MECKLENBURG COUNTY
Park and Recreation Department

MEMORANDUM

DATE: February 23, 2023

RE: Rezoning Petition #2022-161
PID# 19906169

SHEET NO.	SHEET NAME
1 of 3	CONCEPTUAL SITE PLAN
2 of 3	TECHNICAL DATA
3 of 3	MASTER PLAN

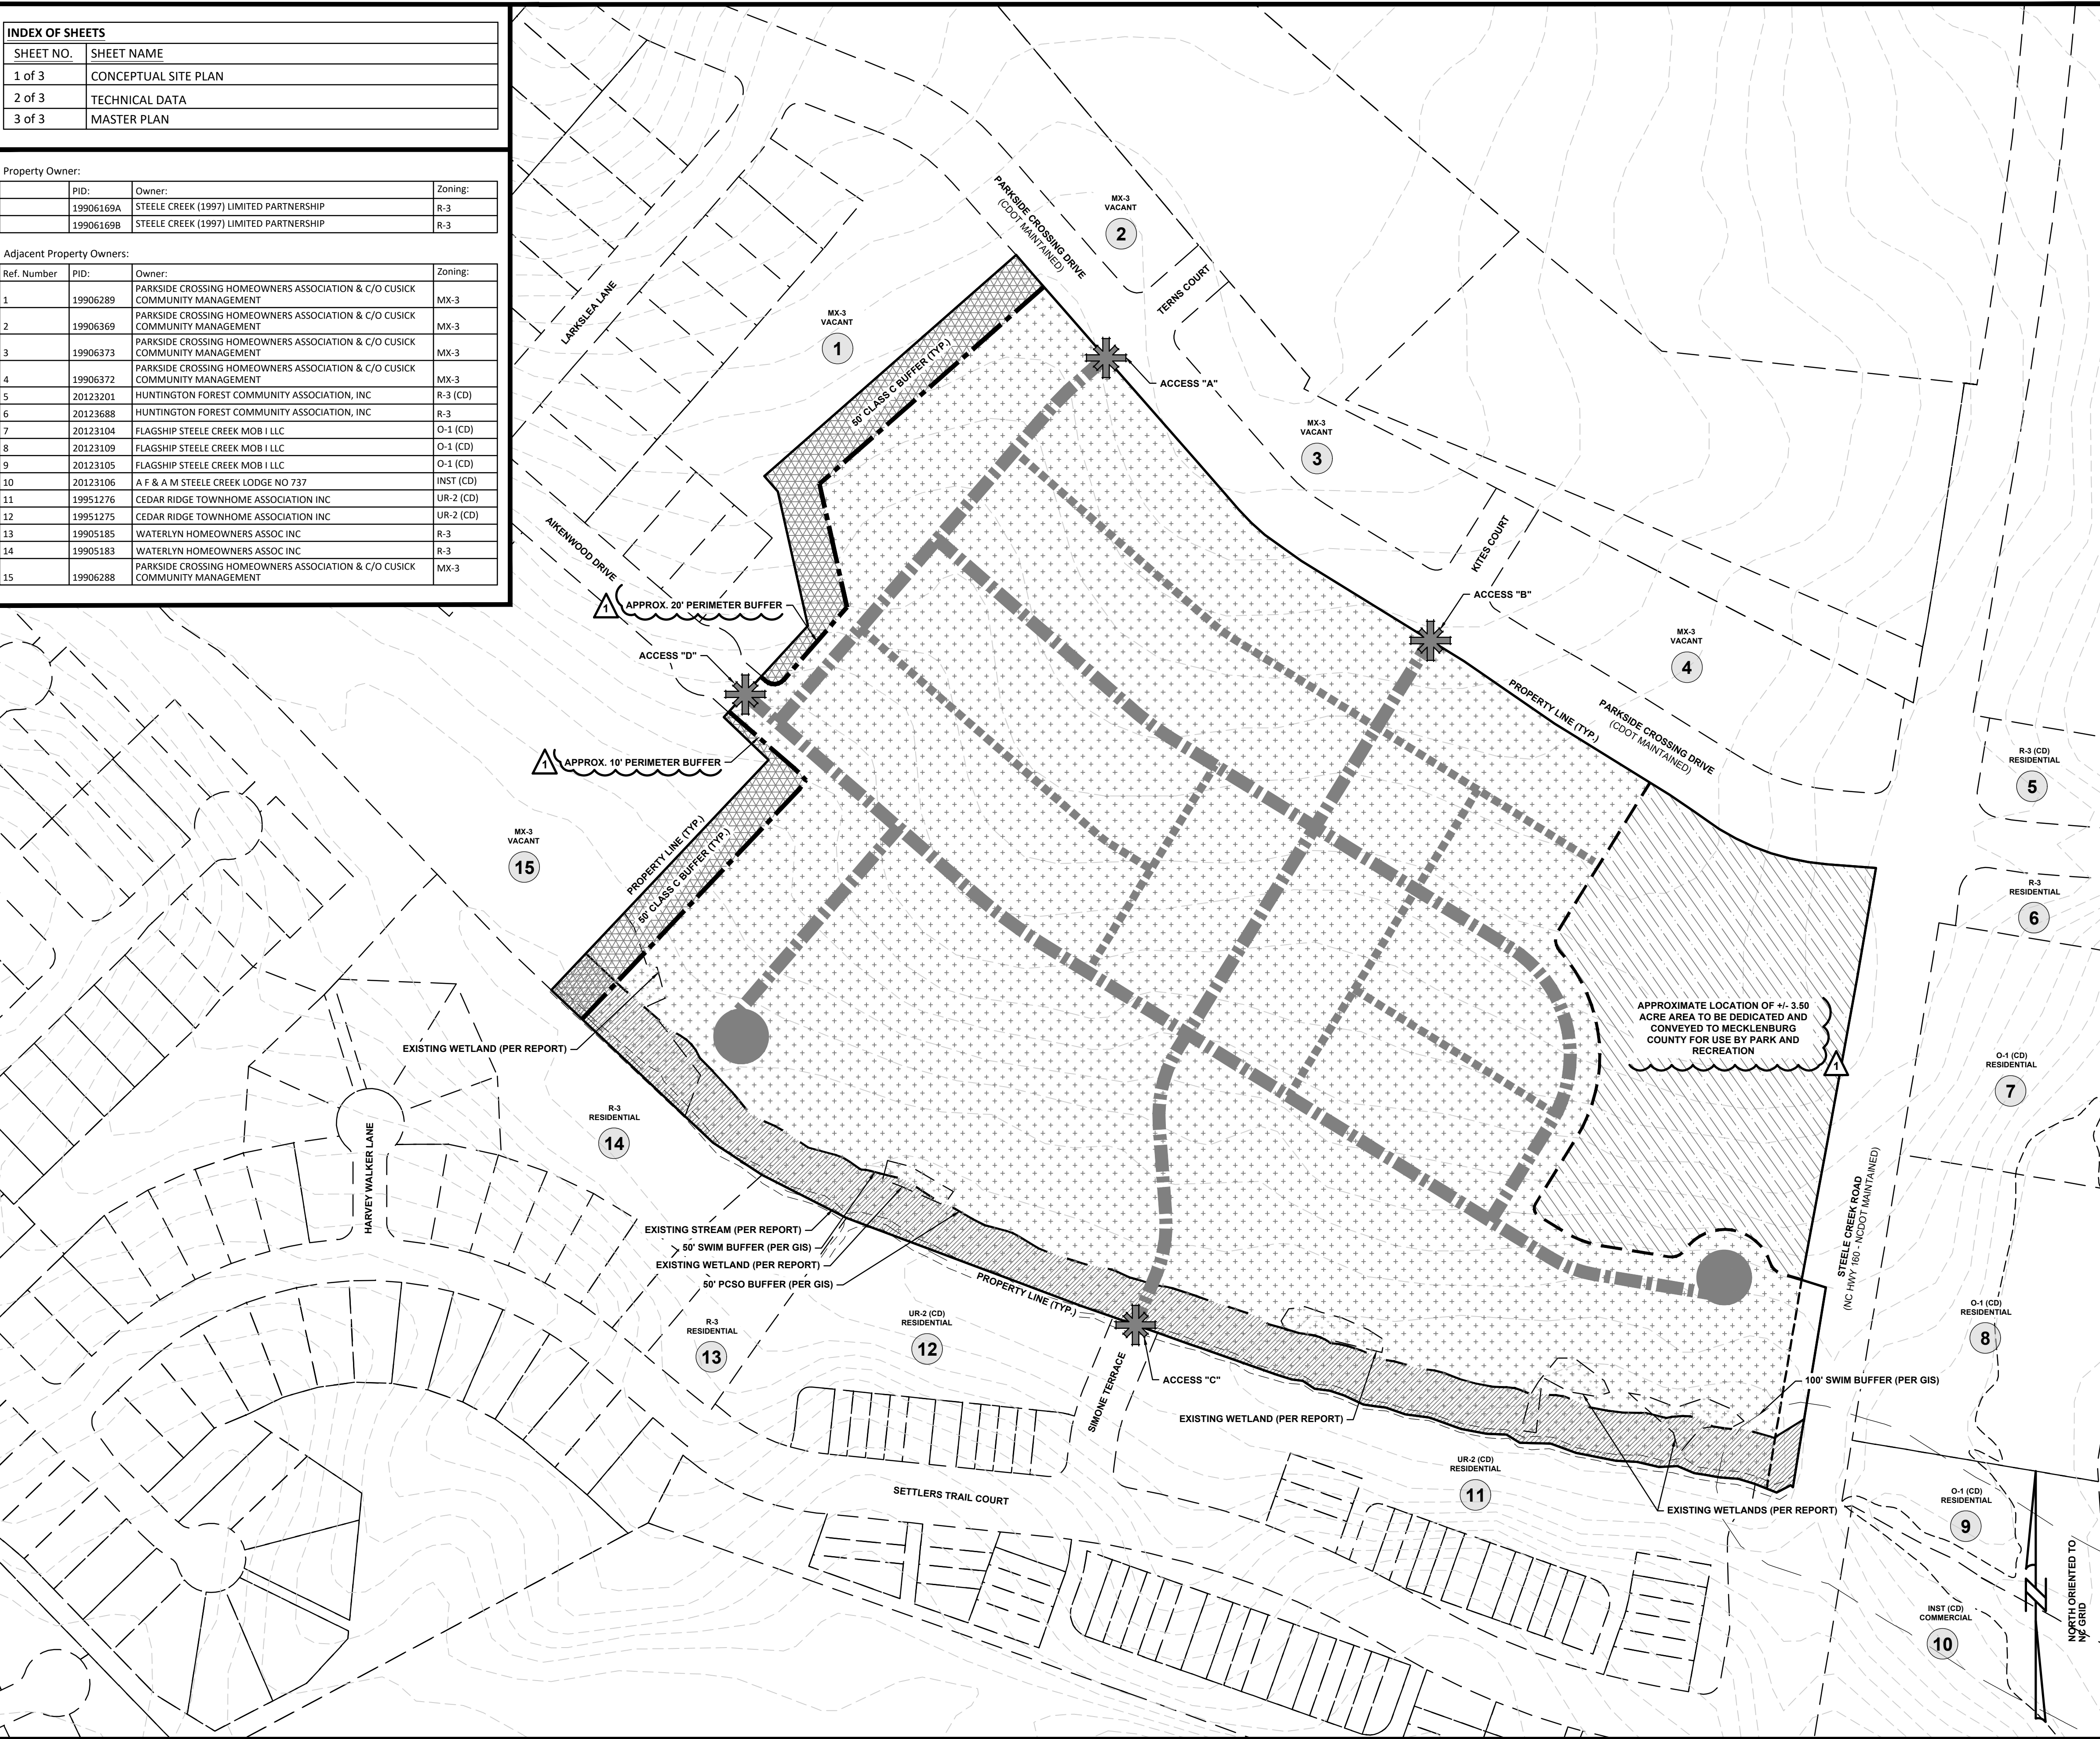
Plans show a proposed 3.5 acre public park to be dedicated to Mecklenburg County. The rezoning note should read that the parcel shall be "dedicated and conveyed to Mecklenburg County for use by Park and Recreation."
